City of Portland, Maine - Building or Use Permit Application
 389 Congress Street, 04101 Tel: (207) 874-8703, Fax: (207) 874-8716

| Permit No: 04-0917 | Issue Date: | CBL: 015 F019001 |

| Location of Construction: 71 Melbourne St | Owner Name: Richards Tammy K | Owner Address: 71 Melbourne St | Phone: 207-749-6720 |

| Past Use: residential | Proposed Use: residential - build 11-6" x 16' addition | Permit Fee: \$309.00 | Cost of Work: \$31,875.00 | CEO District: 1 |

A 1	PLANS	WORKING	04.30.04	RICHARDS ADDITION 71 MELBURN STREET	ARCHITECTURE MUNIRO chrismuniro@usa.net
		REVISED BLDG PERMIT & REVISE	06.04.04 06.18.04

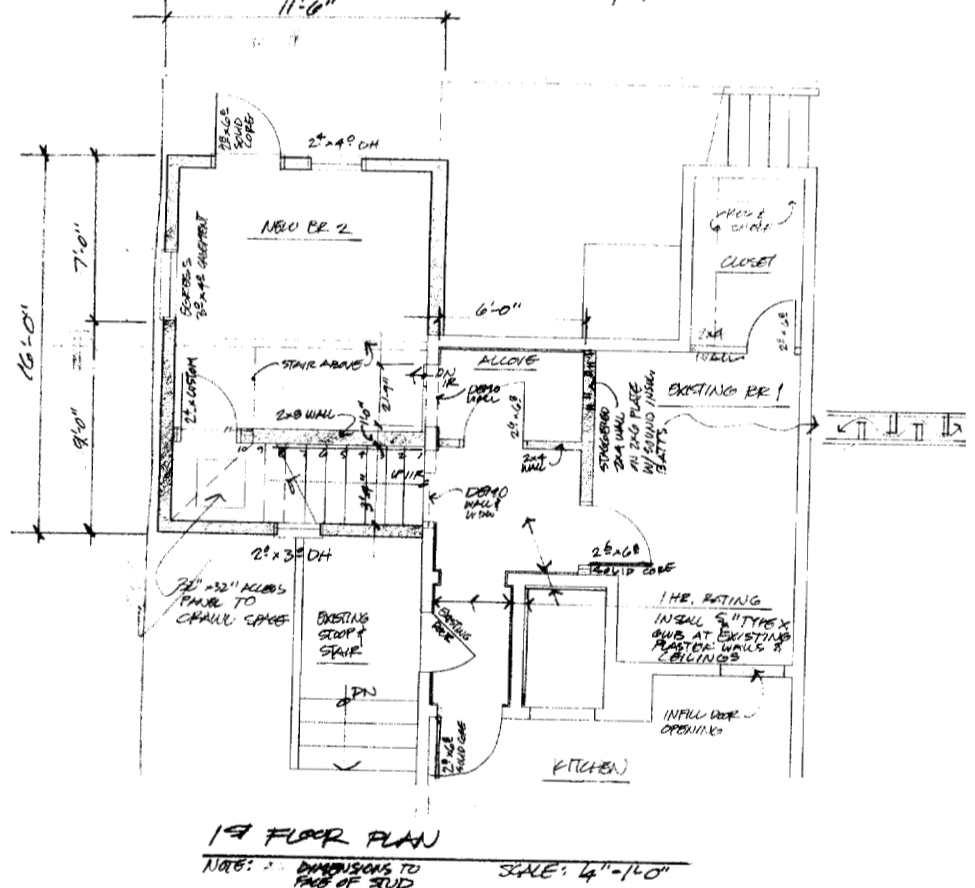
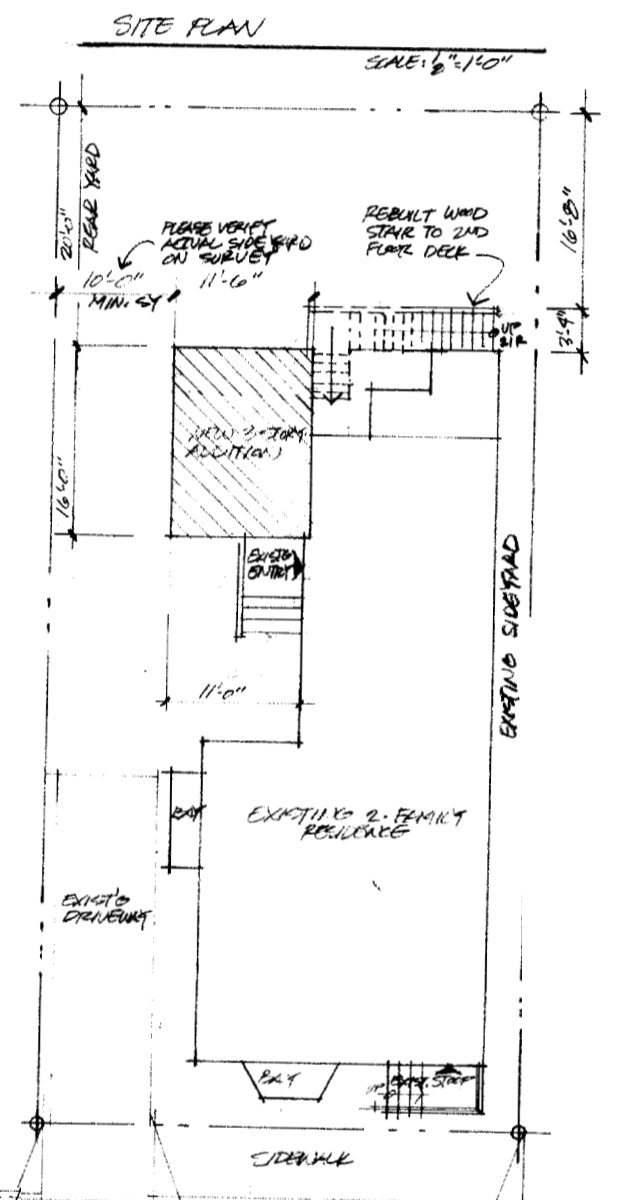
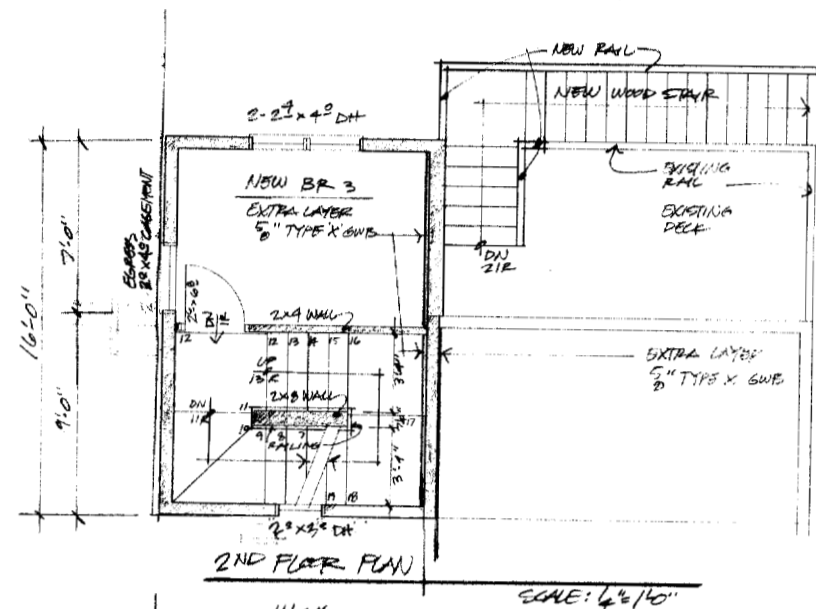
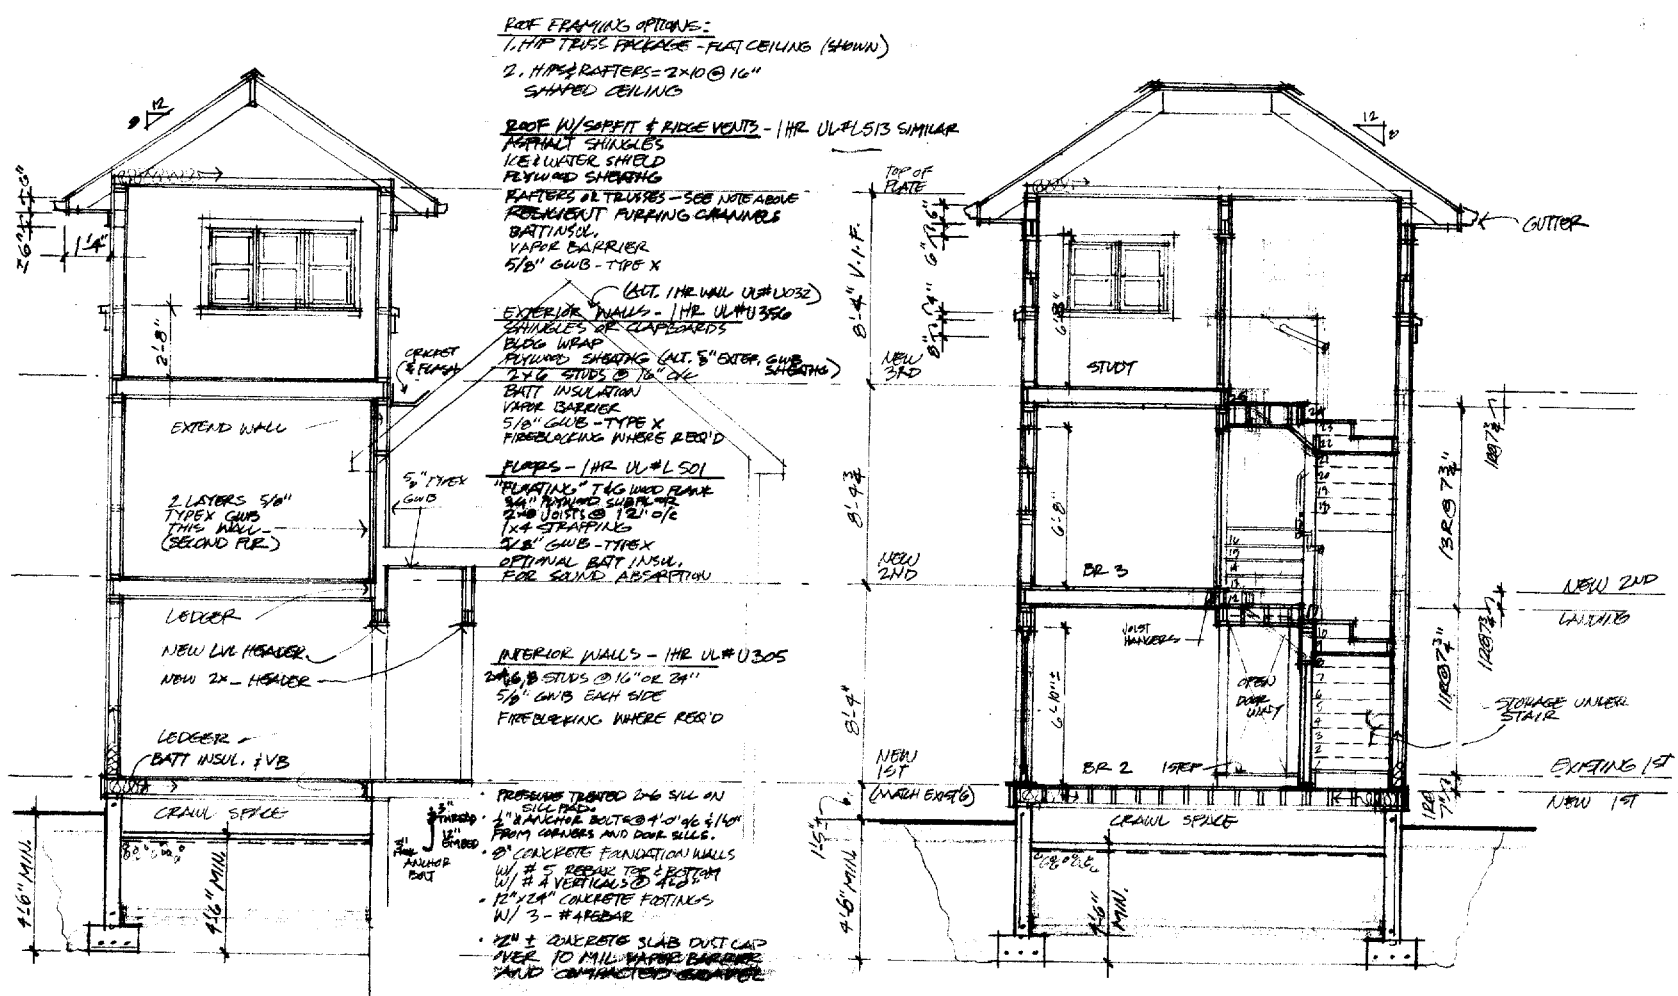
| 1) As discussed, this permit DOES NOT include the replacement of the rear fire escape. A separate permit must be pulled for that. | | | |
| 2) As discussed, hardwired interconnected battery backup smoke detectors shall be installed in all bedrooms, on every level, and in a common area. | | | |

| 7/2/04-tmm: Need 11" x 17" plans, better detail on 5A construction, details on rear stair, winder detail, anchor bolts, and size of access panel to crawl space. - went over w/owner |

| 7/16/04-tmm: ok to issue - rec'd all of the above. |
